Application M/56/15/HH
31 Sea Way, Middleton-On-Sea, West Sussex, PO22 7RZ

We are writing to object to the revised proposals. We welcome the omission of the freestanding garage to the front of property, however we are still of the opinion the remaining proposal are a gross over development of the site which will effect our enjoyment and amenity of our property. The proposals are also clearly contrary to the Middleton on Sea Village Design Statement, specifically the *Future Development Guidelines* which states;

Proposed Floor Plans
- Ground Floor
- First Floor
- Roof Plan

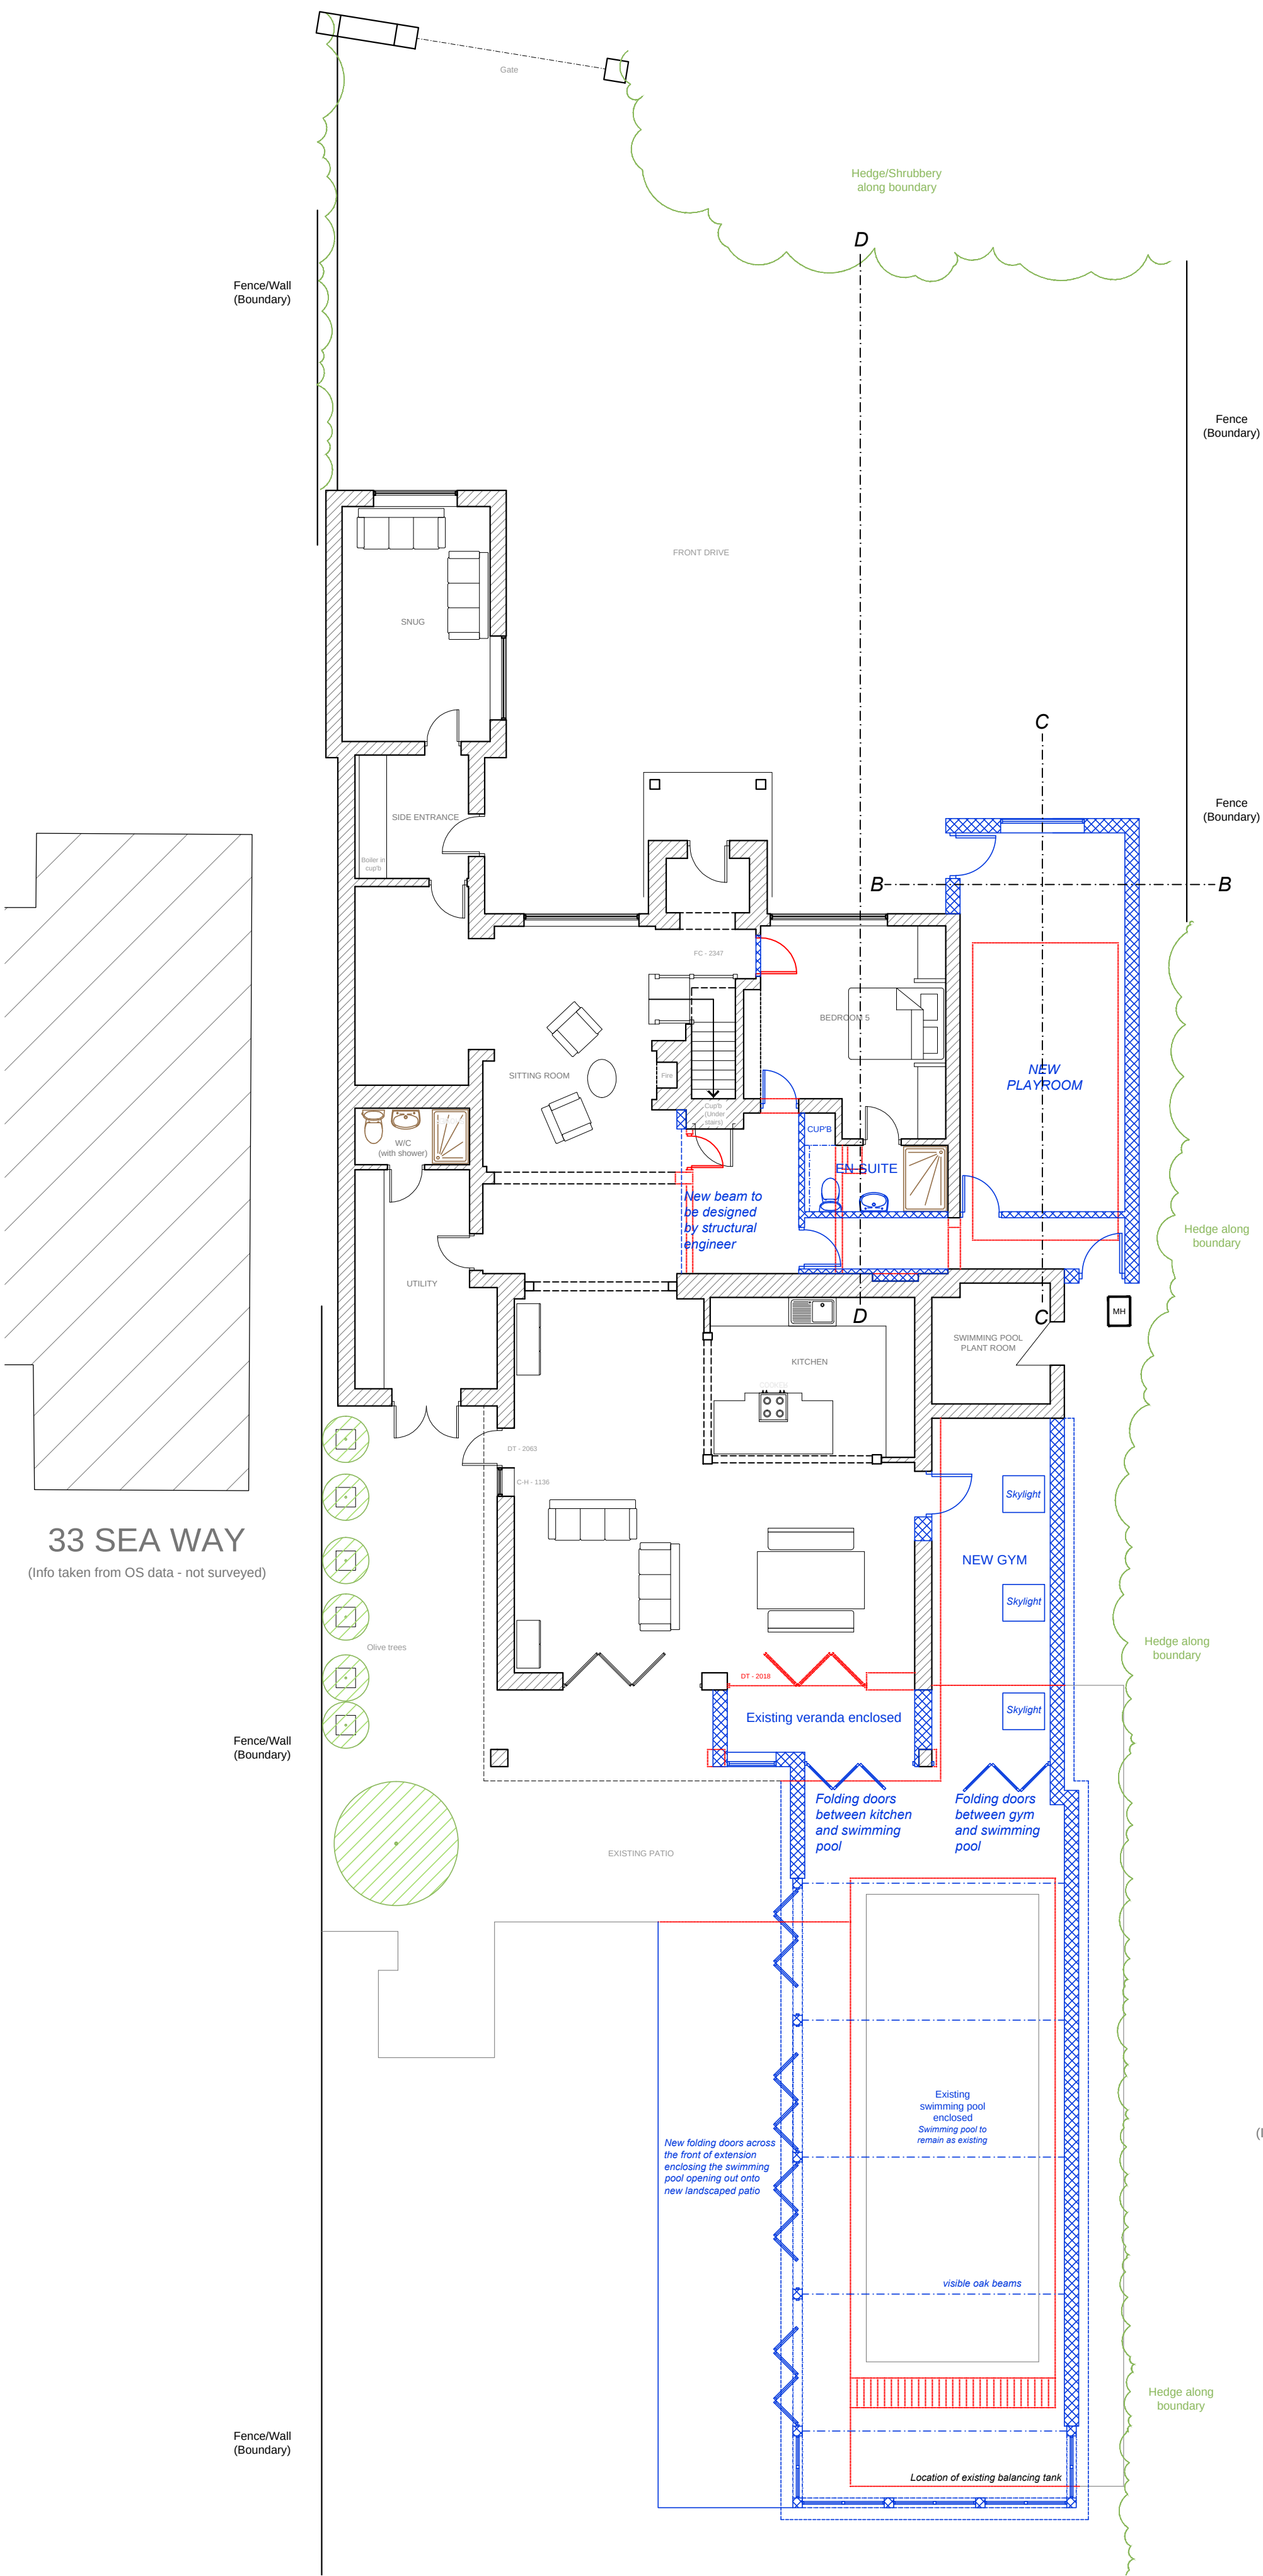
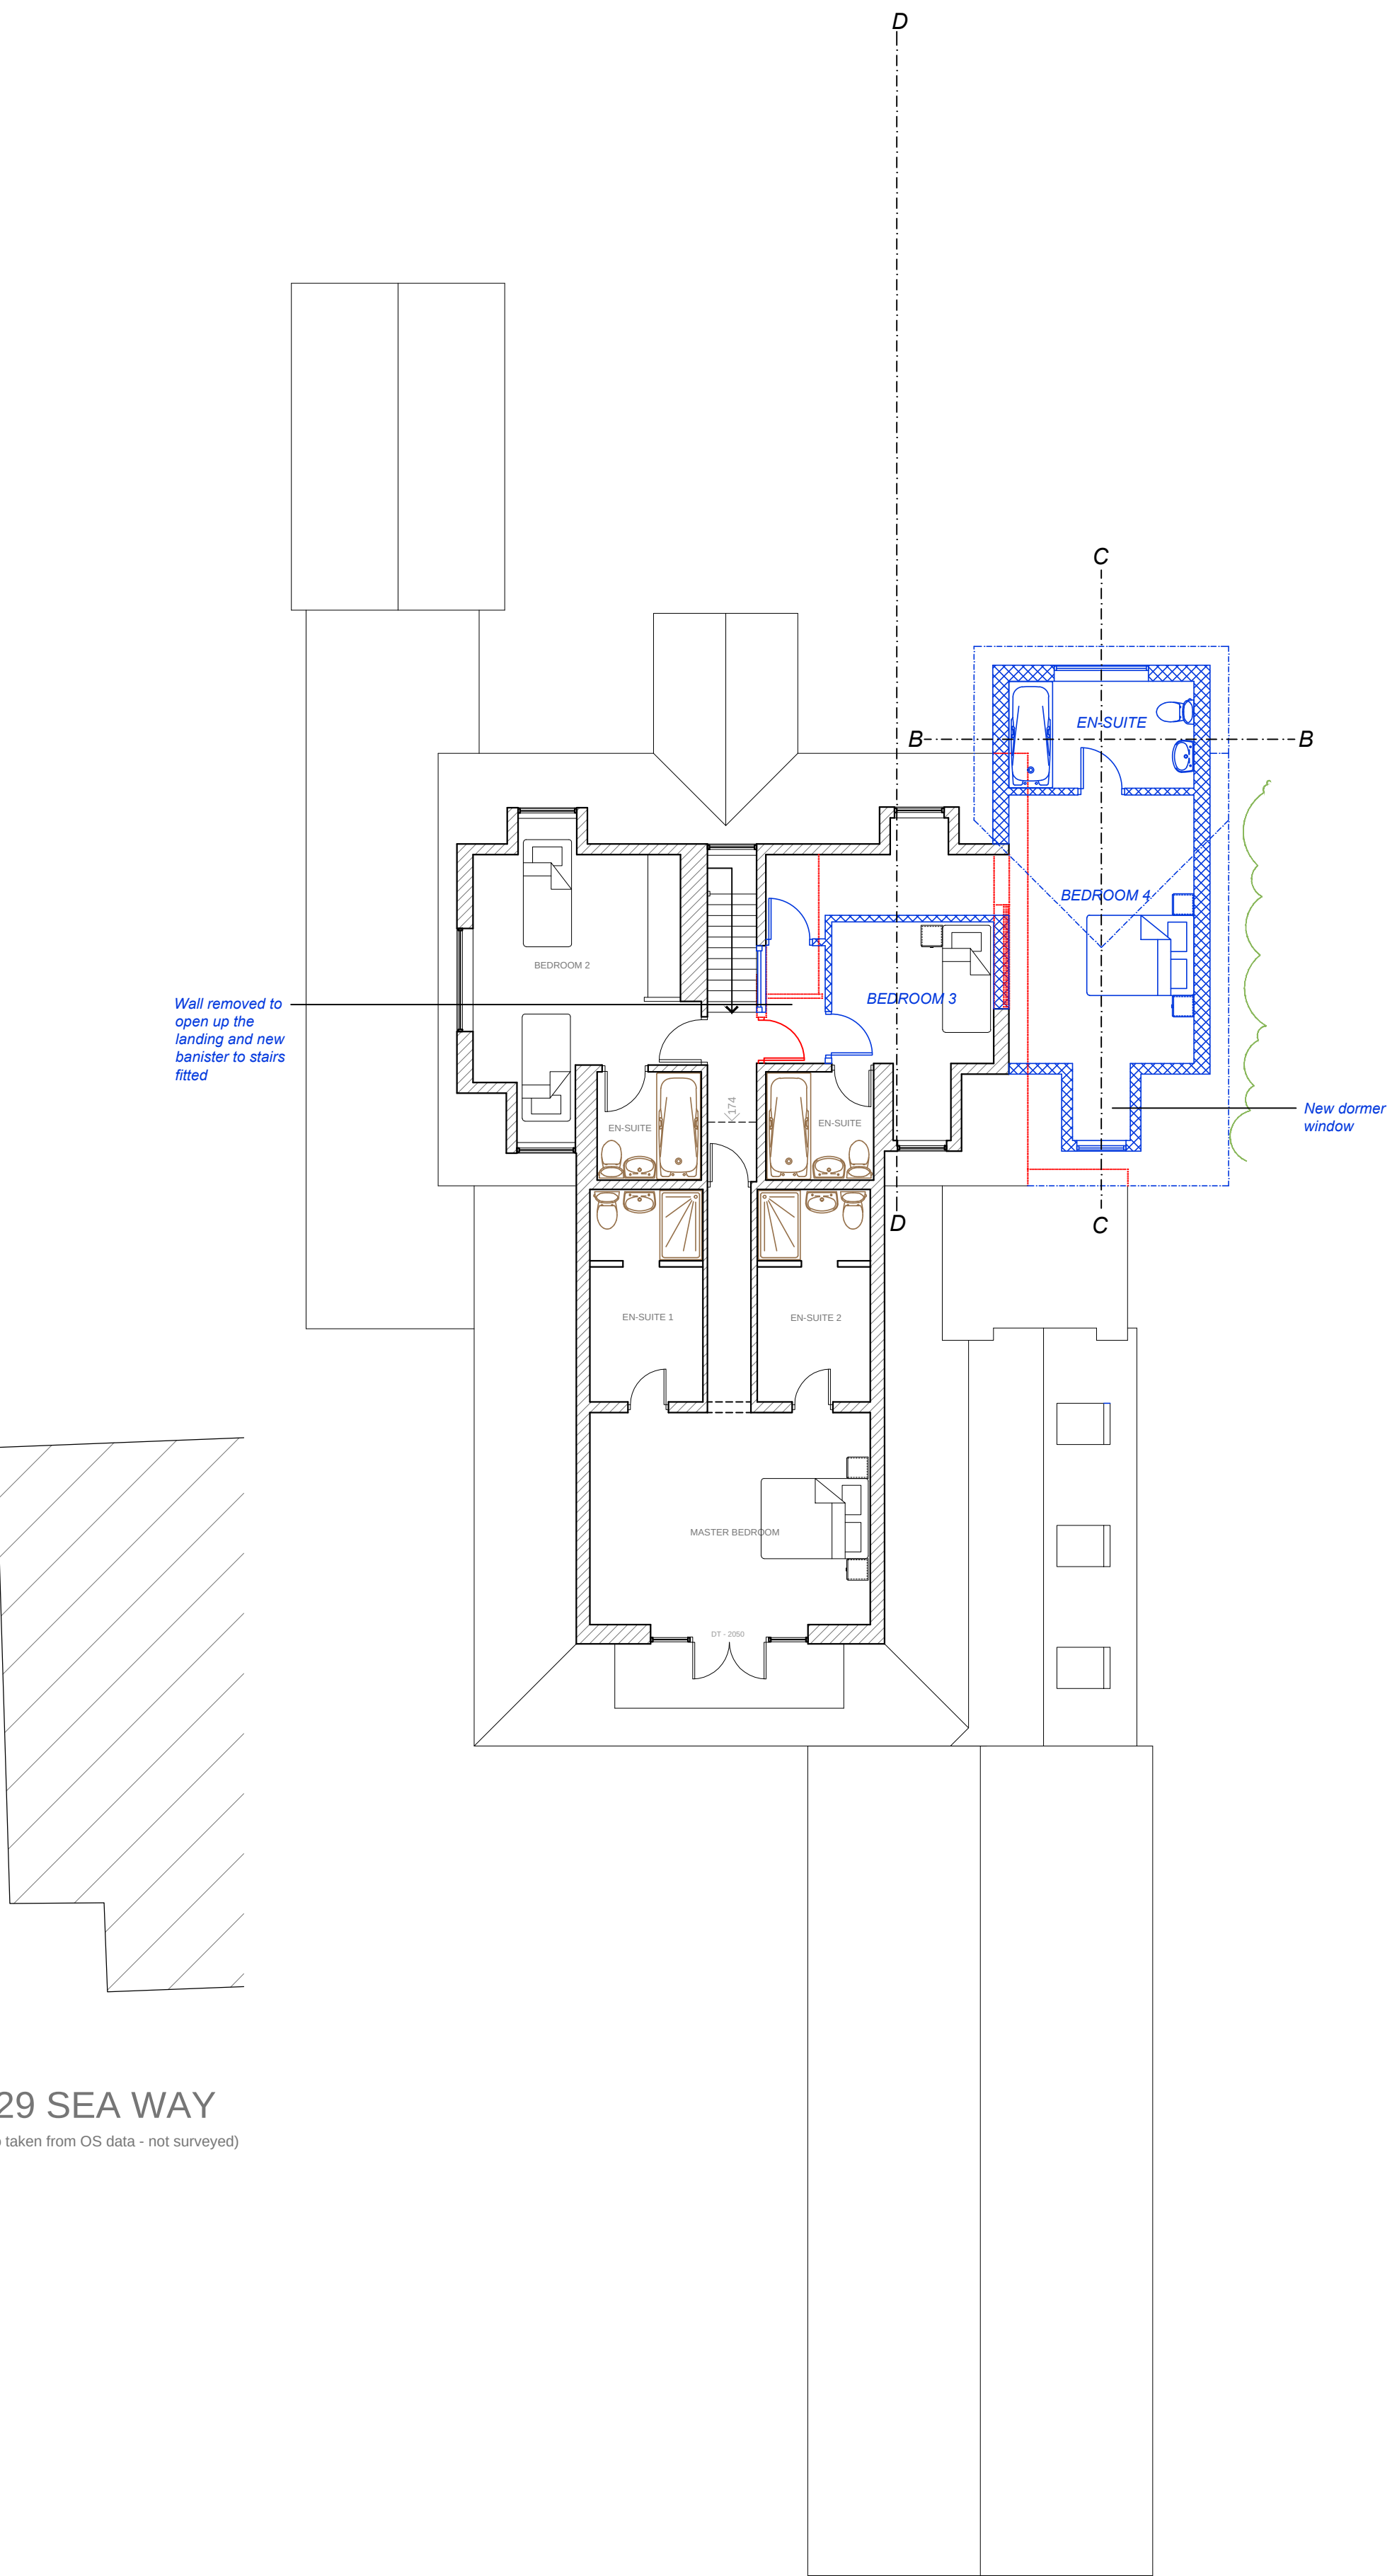
The revised proposal does not change any element of the two storey side extension and our previous objections are unchanged.

Planning applications are to be judged on an individual basis but also viewed against the previous developments on the site and it would appear that No. 31 has been evolving vertically from bungalow to house and now horizontally to fill the site from each neighbour's boundary. This two storey side extension will dominate our house overshadowing our front windows and entrance foyer particularly the evening sunlight.

The 1m side access does not take into consideration the 0.3m overhang of the eaves of the roof creating an overbearing structure right on the boundary. One of the important characters of the Sea Way is the gaps created between properties not just for the enjoyment of residents but for passers-by viewing the built environment from the coastal path. This extension obliterates this gap and forms a property which is developed from its west to east boundary.

There is also the loss of privacy and overlooking from the new first floor dormer window to the 5th bedroom which looks directly down into our front facing window. The loss of light particularly to this window will be dramatic and is against the Middleton on Sea Village Design Statement, *Future Development Guidelines* and should be refused or reduced greatly so as not to affect our amenity. Rights of lights are also a separate issue we will be investigating further.
